**TOWER 2, LEVEL 23
DARLING PARK, 201 SUSSEX ST
SYDNEY NSW 2000**

30 January 2017

RESPONSE TO SUBMISSIONS - OAKDALE SOUTH ESTATE - SECTION 96(2) (SSDA6917)

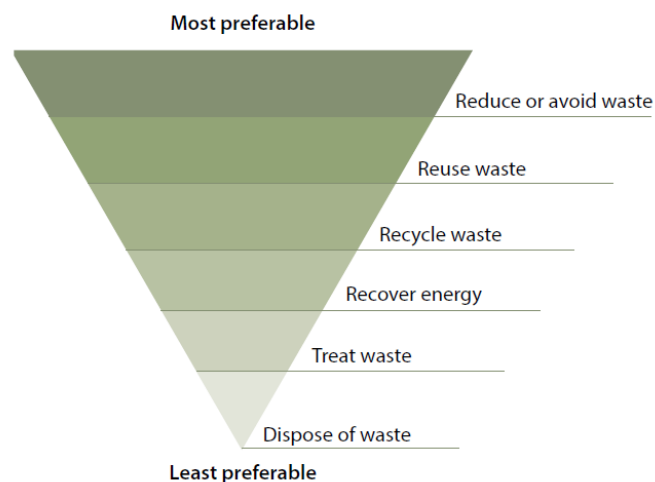
MATTERS RAISED	APPLICANT RESPONSE
NSW DEPARTMENT OF PLANNING & ENVIRONMENT	
Visual <ul style="list-style-type: none"> <i>Please provide photomontages from view 06 in the Visual Impact Assessment showing the approved and proposed layout of the estate without landscaping treatments.</i> 	<p>The Visual Impact Assessment has been updated to include a comparison between the as approved versus proposed View 06 without landscape. Photomontages of View 06 have been prepared by E8 Urban and are submitted with this RTS at Attachment A.</p>
Noise <ul style="list-style-type: none"> <i>Please provide full details of the dimensions of the noise walls, including all dimensions on updated civil, architectural and landscape plans.</i> 	<p>Civil, Architectural and Landscape plans have been updated to include the dimensions of the noise barrier. Refer to Attachments B, C and D.</p>
Vegetation Management Plan and Biodiversity Offset Area <ul style="list-style-type: none"> <i>Following the meeting between the Department, the Office of Environment and Heritage and yourself on Wednesday 30 November 2016 a revised VMP will need to be provided reflecting the proposed modifications with respect to the current modification application; and</i> <i>Clarification should be provided for references to 'ongoing management works' in sections 2.5.3, 2.6.1, 2.6.6 and 3.4 of the VMP, noting that OEHL do not agree to any ongoing conservation/management works within the proposed bio-banking site.</i> 	<p>The Vegetation Management Plan (VMP) has been updated to reflect the required modifications by EcoHort and is submitted at Attachment E.</p> <p>The changes made to the VMP include the removal of references to ongoing management of the riparian and biodiversity zones. In addition, other landscaping zones which are not part of the bio banking area and which are subject to other consent conditions and were not relevant to the VMP have been clarified. These area included:</p> <ul style="list-style-type: none"> Defendable zones and associated embankment treatment Bio-retention basins Water course re-alignment

- Amended Visual Impact Assessment Addendum prepared by Urban8 – photomontages from view 06 showing the approved and proposed layout of the estate without landscaping. Submitted at **Attachment A**.
